Application Ref:	2026/0024			 Ribble Valley Borough Council www.ribblevalley.gov.uk					
Date Inspected:	13/03/2026	Site Notice:	N/A						
Officer:	EP								
DELEGATED ITEM FILE REPORT:					REFUSAL

Development Description:	Proposed first floor extension above existing attached garage.
Site Address/Location:	Casa Mia 8 Beasley Avenue Simonstone BB12 7HU

8 BEAULEY AVENUE · SIMONSTONE ·
ELEVATIONS OF THE WHOLE BUILDING
AS PROPOSED.

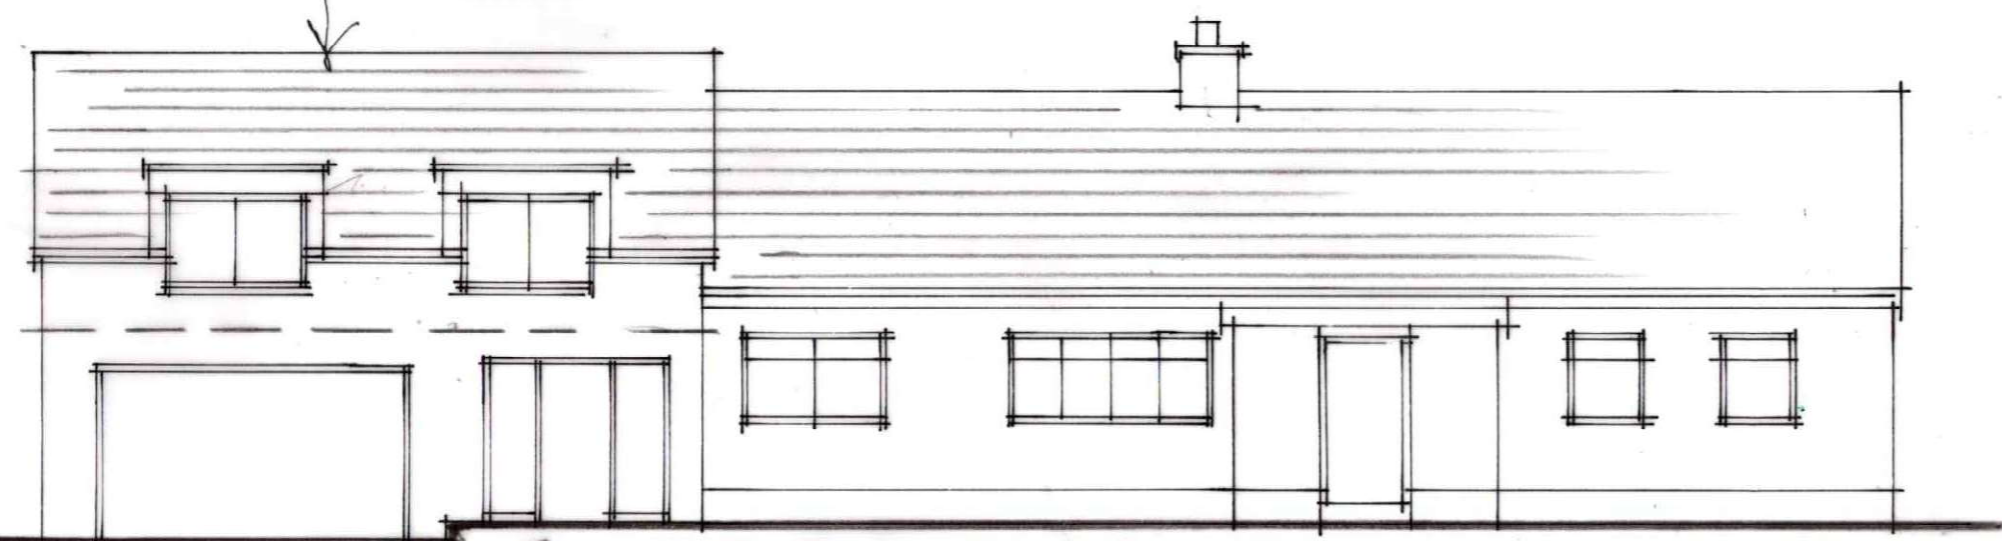
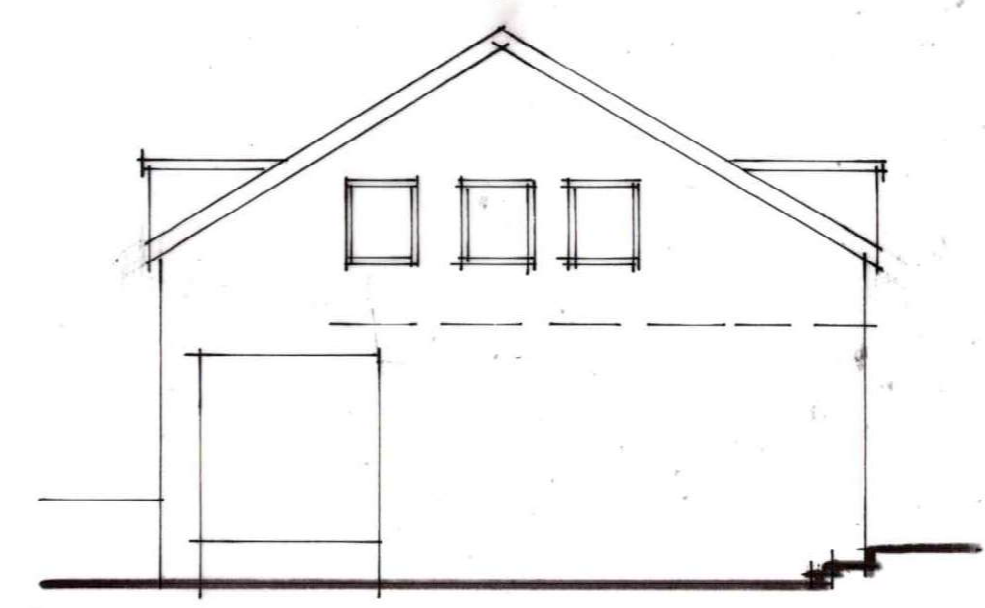
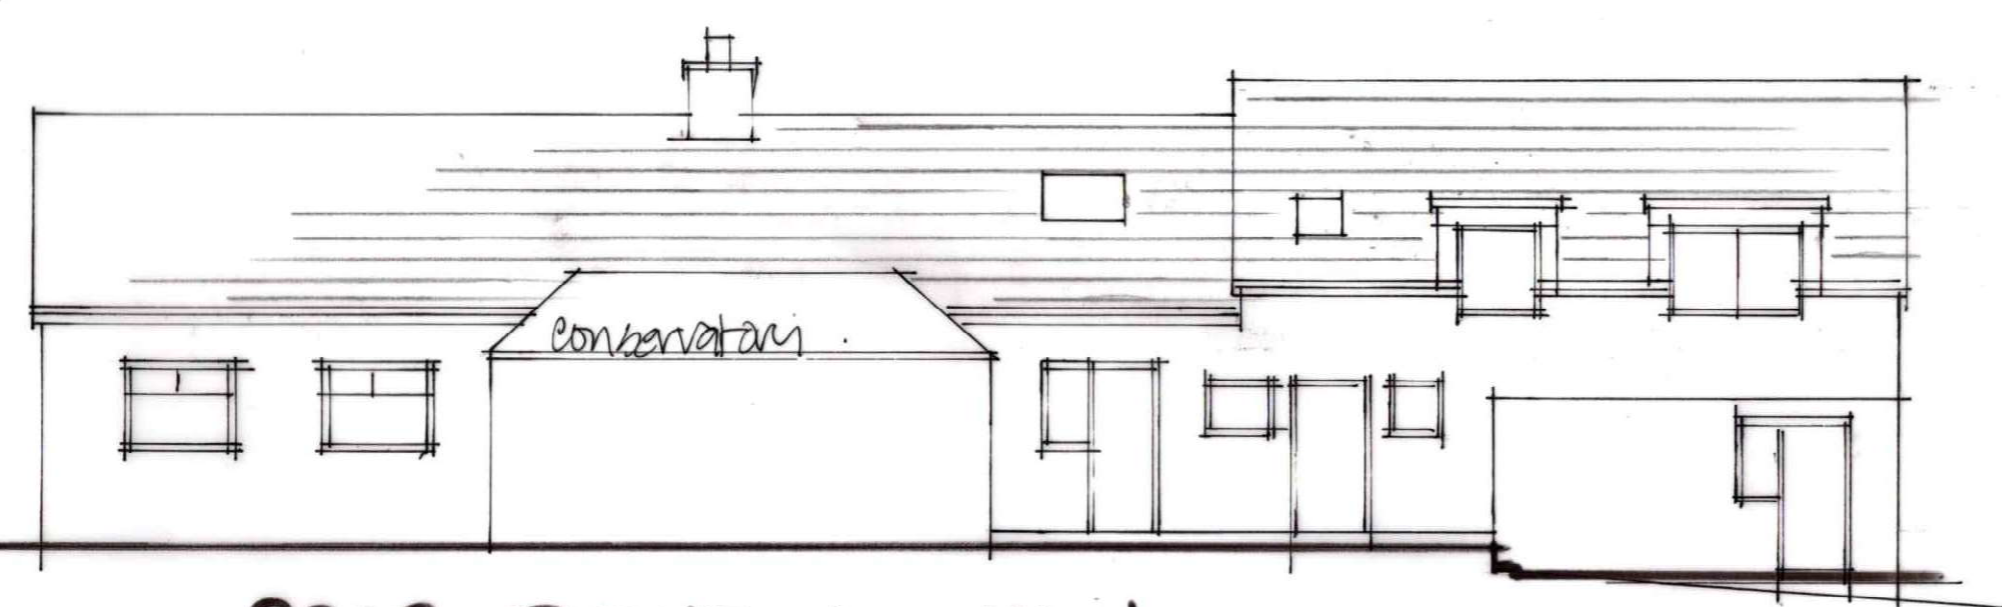
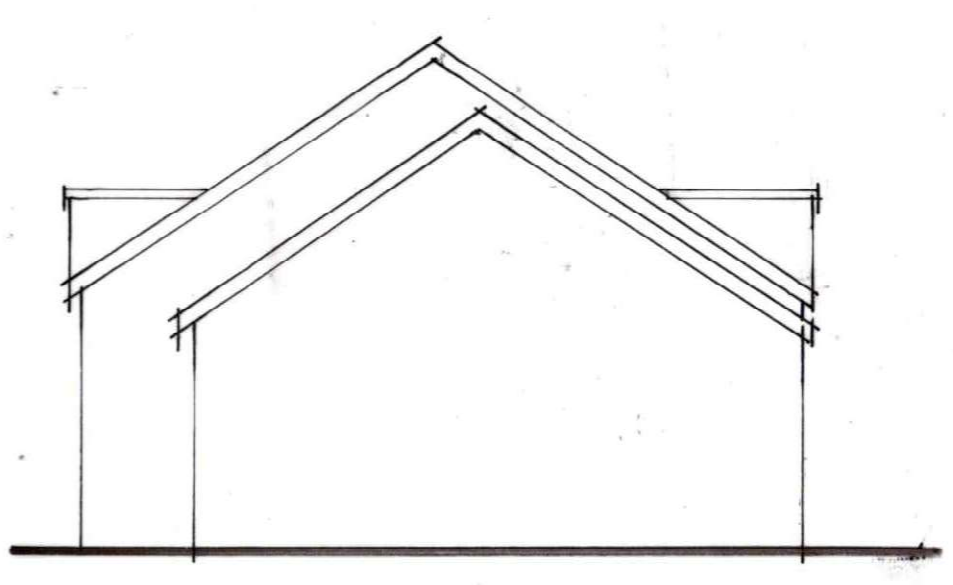
The proposed extension will comprise a maximum height of 6.8m at its tallest point, this is substantially taller than the existing single-storey garage which measures approximately 3m in height. The application dwelling sits on a higher ground level when compared with the neighbours to the southwest as a result of the sloping topography and therefore there is already a slight sense of overbearing amongst the existing arrangement. However, the introduction of a substantially taller structure adjacent to the southern boundary would exacerbate this overbearing impact to an unacceptable degree. There are a number of windows within the northern side elevation of the neighbouring property, along with a conservatory featuring an entirely glazed roof. In addition, there is a section of residential curtilage to the north of the neighbouring dwelling immediately adjacent to the proposed development. Given the proximity of the proposed extension to the neighbouring dwelling itself, which desktop analysis shows to be approximately 8.5m, and paired with the change in ground level, there is potential for a degree of light to be lost along with an overbearing impact to neighbouring habitable windows, and to residential curtilage, resultant of the proposed development.

Furthermore, there are three window openings proposed in the southwest side elevation of the proposed extension at first floor level. Given the proximity of these windows to neighbouring habitable windows and residential curtilage, there would be new opportunity for overlooking created and subsequently a loss of privacy resultant. It would be possible for these windows to be obscurely glazed which could be achieved via planning condition. However, given the close proximity to the boundary and number of windows proposed, there would still be an increased perception of overlooking which would be of harm to the residential amenities of neighbouring receptors.

As such, the proposed extension would result in unacceptable harm to neighbouring amenity by virtue of the proposed scale of the extension which would inflict unacceptable overbearing impact and loss of light to habitable windows and residential curtilage. In addition, the creation of new window openings at first floor level immediately adjacent to the shared boundary would create new opportunity for overlooking and

The proposed extension will be sited above the existing attached garage structure. The development will sit forward of the principal and rear building lines of the application dwelling with the proposed ridge height exceeding that of the main dwelling. When viewed from the public highway the height increase is approximately 3.5m when compared to the existing single-story garage, with the proposed ridge being 6.5m above ground level. As a result, the proposed extension would exceed the scale of the main dwelling and would therefore fail to remain subservient, taking an over dominant position within the street scene. The proposed extension would arguably read as the main dwelling, with the existing dwelling appearing as extensions. Furthermore, by virtue of the sloping topography of Bealey Avenue, the height of the proposed extension would be exacerbated significantly.

Whilst there is no defined sense of uniformity within the streetscene, an extension of this nature would appear significantly out of character in as much that the proposal fails to remain subservient to the host dwelling by virtue of its scale and design. As a result, the development would result in the creation of an anomalous and disproportionate addition to the dwelling which would be of harm to the character and visual amenities of the area contrary to Policies DMG1 and DMH5 of the Ribble Valley Core Strategy and Paragraph 135 of the National Planning Policy Framework.

8 BEAULEY AVENUE
SIMON STONE

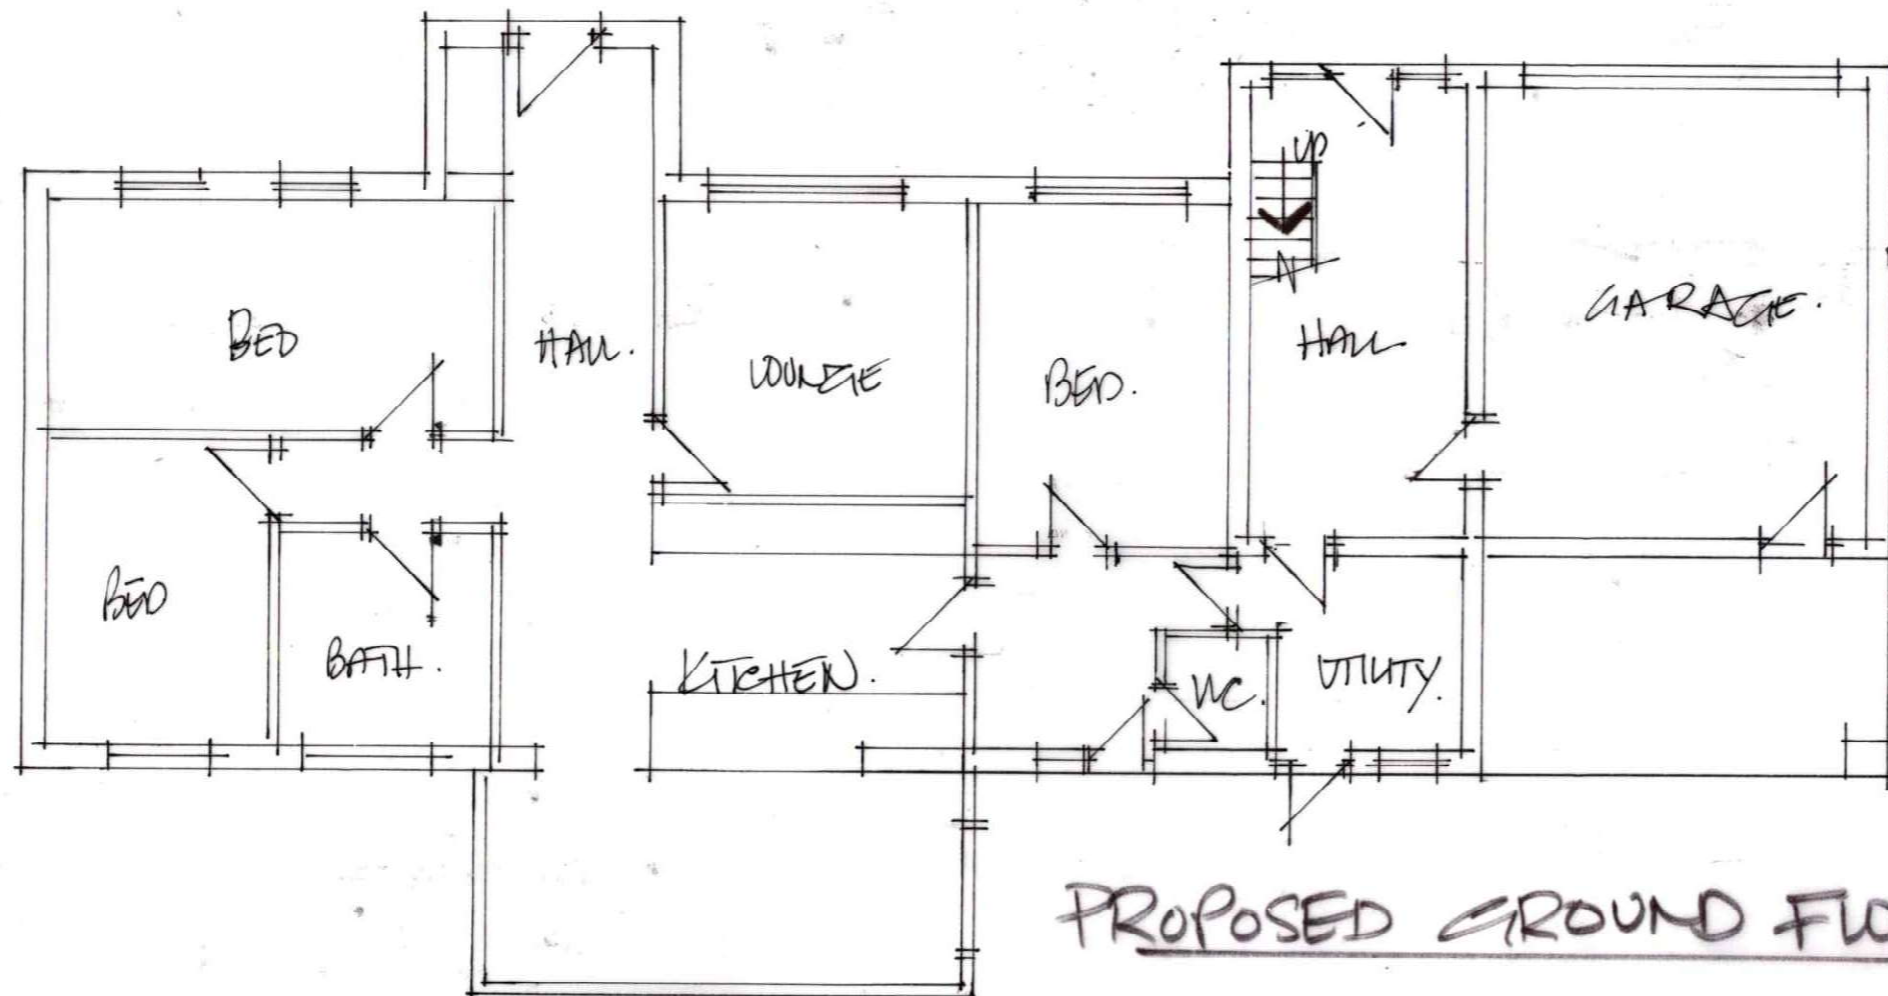
The proposed first floor extension is location to the southwestern side of the application dwelling where No.4 and No.4a Beauley Avenue are located. The existing attached garage structure is approximately 3m from the shared boundary with the neighbours to the southwest, subsequently the proposed first floor extension has the potential to adversely impact receptors in respect of light lost and overbearing impact.

It is recognised that there is an existing first floor balcony above the existing garage structure, however, this is set away from the adjoining shared boundary and therefore does not afford the same levels of overlooking as the proposed windows.
